13 May 2019

Department of Planning & Environment  
Resource Assessments  
GPO Box 39  
SYDNEY NSW 2001

**MANDALONG SOUTHERN EXTENSION PROJECT – NOTICE OF EXHIBITION - SSD 5144 MOD 8**

Figure 4 | Road intersections impacted by increase in proposed traffic

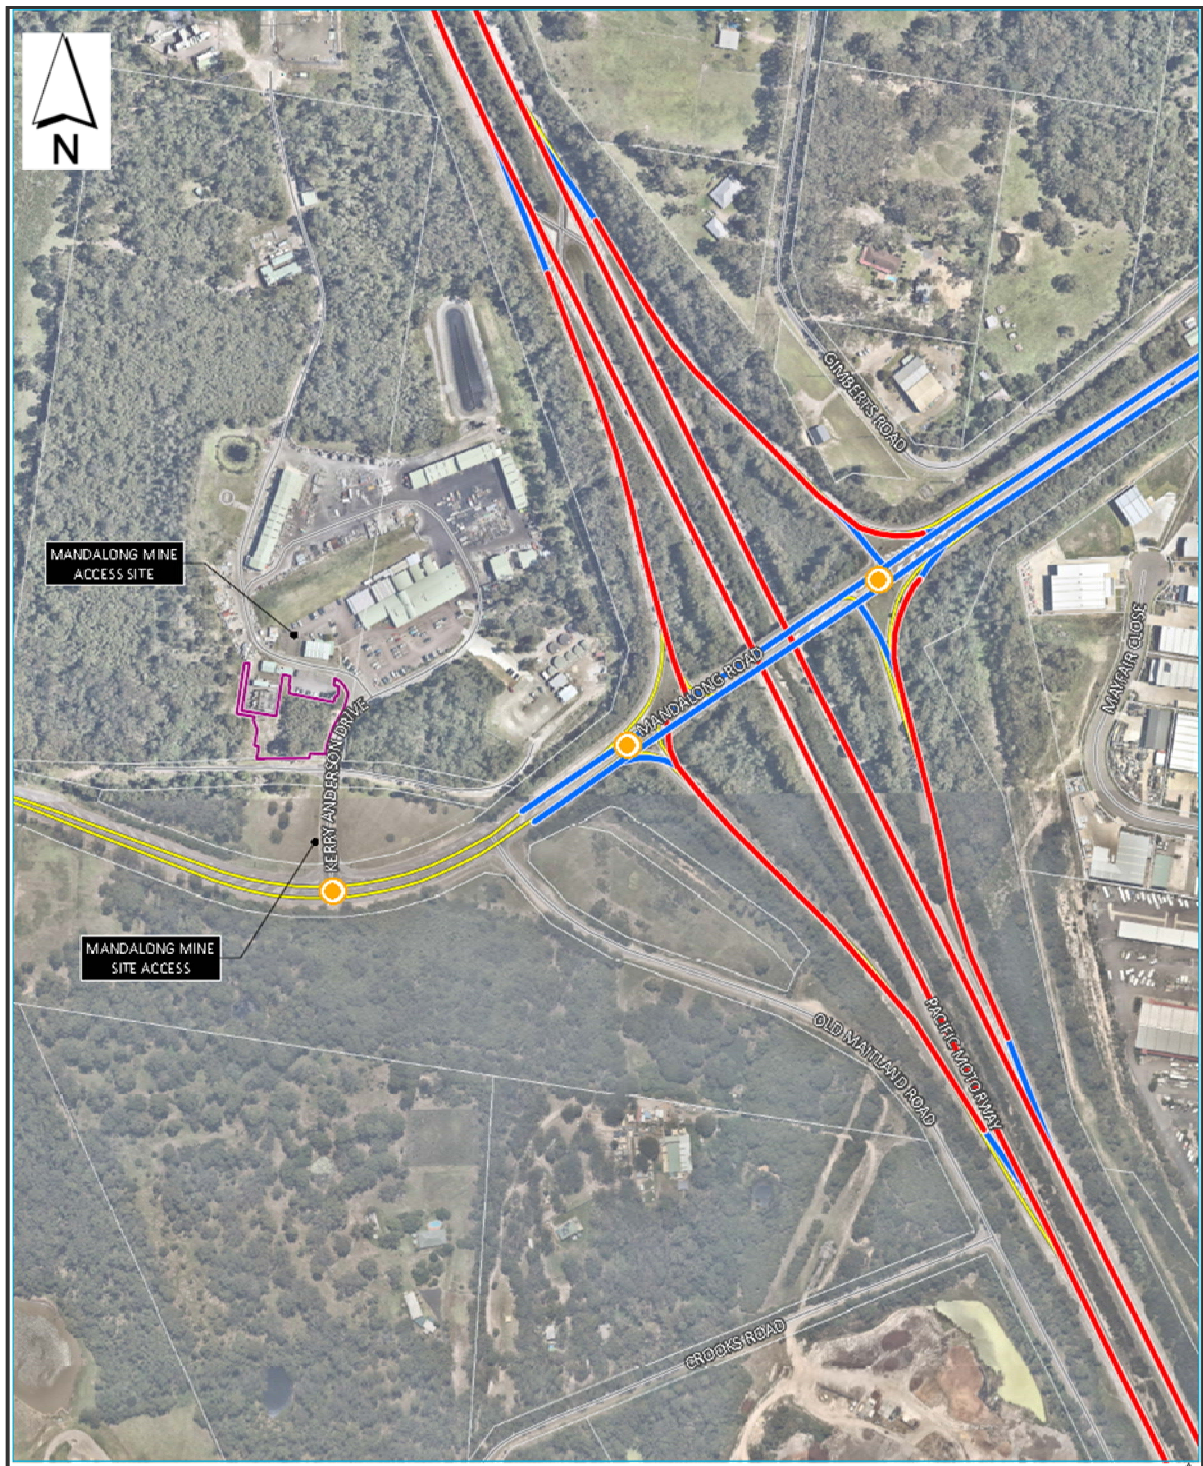
- The TIA appears to provide different results between Table 4.3, which is a summary of the Sidra analysis, and Appendix D & E which shows the Sidra output results. Table 4.3 shows that the DOS in the PM peak exceeds 0.9 for the eastern interchange ramp, which is considered unstable flow. This is not shown within the Sidra appendices. This has been attached in Annexure A.

- The operation of the eastern interchange ramp is to be confirmed. The eastern ramp contains the critical movement, which is the right turn from the ramp onto Mandalong Road.
